From: Michael Eastham
Sent: 17 April 2019 13:38
To: Planning.Responses
Cc: Nicola Spencer; 'Steven Shaw'; 'Jamie Brown'
Subject: AL/129/18/OUT - Land East of Orchard Gardens, Woodgate

WEST SUSSEX COUNTY COUNCIL CONSULTATION

TO:	Arun District Council FAO: Michael Eastham
FROM:	Highways, WSCC
DATE:	17/01/2019
LOCATION:	Land East of, Orchard Gardens, Woodgate, Chichester
SUBJECT:	AL/129/18/OUT Outline application with some matters reserved for the development of 55 No. units with public open space & affordable housing (resubmission following AL/111/16/OUT).
DATE OF SITE VISIT:	Previously in 2016 as part of AL/111/16
RECOMMENDATION:	☐ Advice ☐ Objection ☐ Modification ☒ No Objection ☐ More Information ☐ Refusal
INFRASTRUCTURE DELIVERY PLAN CONTRIBUTION TOTAL:	£392,150

Drawing 5919/100 showing Right Turn Lane

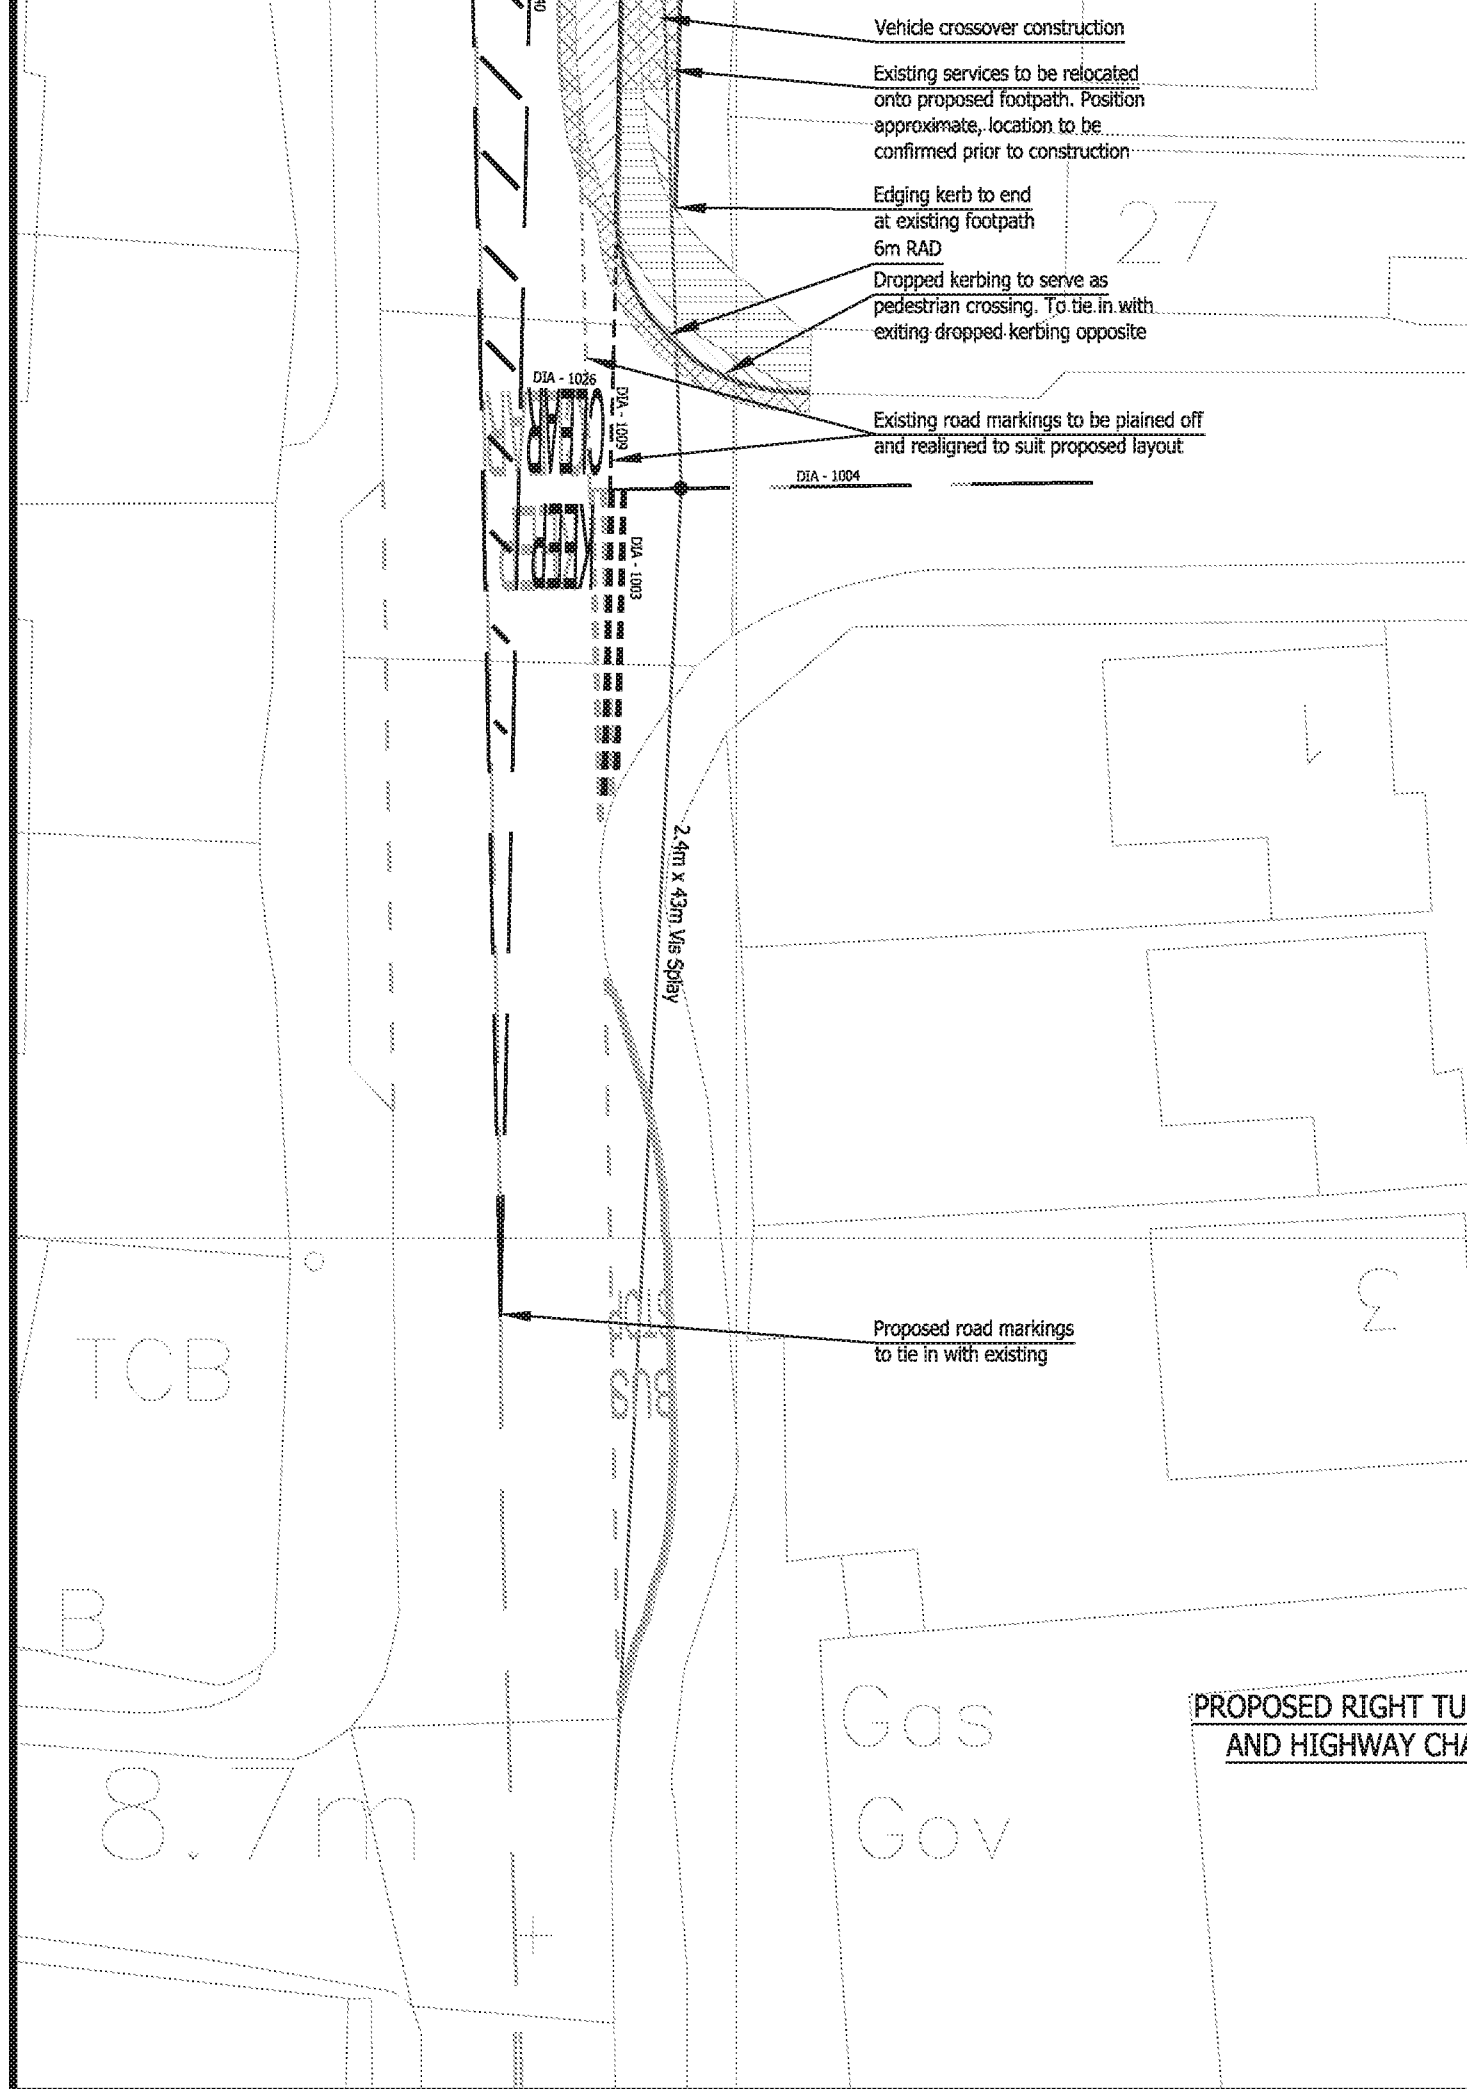
The LHA has held discussions with the applicants Transport Consultant on the areas forming part of the objections to the application consultation from November 2016, namely the integration with the Hook Lane RTL and the technical details of the proposed RTL. Following this the LHA are now satisfied with the proposed RTL based on the changes that have been made in accordance with drawing number 5919/100 Rev D, this includes:

- **Pedestrian Links**-Where the pedestrian crossing is located, the drawing has been modified to demonstrate the access points of the adjacent properties on the road to the east to ensure that there is no conflict.

- **Swept Path Diagrams and RTL**-The RTL has been widened to circa 3.5 metres and the accompanying swept path has been modified to show that it does not overhang onto the A29.

- **Alignment of RTL** - The southbound carriageway taper has been adjusted to allow for a 1 in 20 tapers.
- **Bus Shelter**-The existing bus shelter has been positioned accordingly to ensure it does not infringe on visibility immediately to the south. The shelter is of a cantilever design and we are satisfied with a cantilever wooden shelter. It is advised that the applicant liaises with the applicant for the Hook lane RTL on its re-location.

- **Visibility Splays at Junction with Orchard Gardens**-We have assessed the proposals against TD42/95 'Geometric Design of Major/Minor Priority Junctions'. The 2.4 by 43 metre splay proposed at the junction of Orchard Gardens is a departure from standards. MfS states that full visibility is not required in low speed urban environments, this proposal is not considered to meet this criteria. In difficult circumstances, the 'x' distance may be taken as a relaxation from 9.0m to 4.5m for lightly trafficked simple junctions, and in exceptionally difficult circumstances, to 2.4m back from the nearer edge of the major road running carriageway. In this instance we would be satisfied with a 3.0 metre 'X' distance by 43 metre visibility splay as a compromise. This has been agreed, but not demonstrated on this particular plan. We would request that the plan is modified to show the previously agreed 3.0 by 43 metre 'X' distance. The land in question for the splay would appear to be within publicly maintainable highway.

Having considered the above and on the basis that the drawing is updated to include the 3.0 metre 'X' distance the LHA does not consider that the proposal would have 'severe' impact on the operation of the highway network, therefore is not contrary to the National Planning Policy Framework (para 32), and that there are no transport grounds to resist the proposal.

No part of the development shall be first occupied until visibility splays of 3.0 metres by 43 metres have been provided at the existing site junction onto Westergate Street in accordance with plans and details submitted to and approved in writing by the Local Planning Authority. Once provided the splays shall thereafter be maintained and kept free of all obstructions over a height of 0.6 metre above adjoining carriageway level or as otherwise agreed.
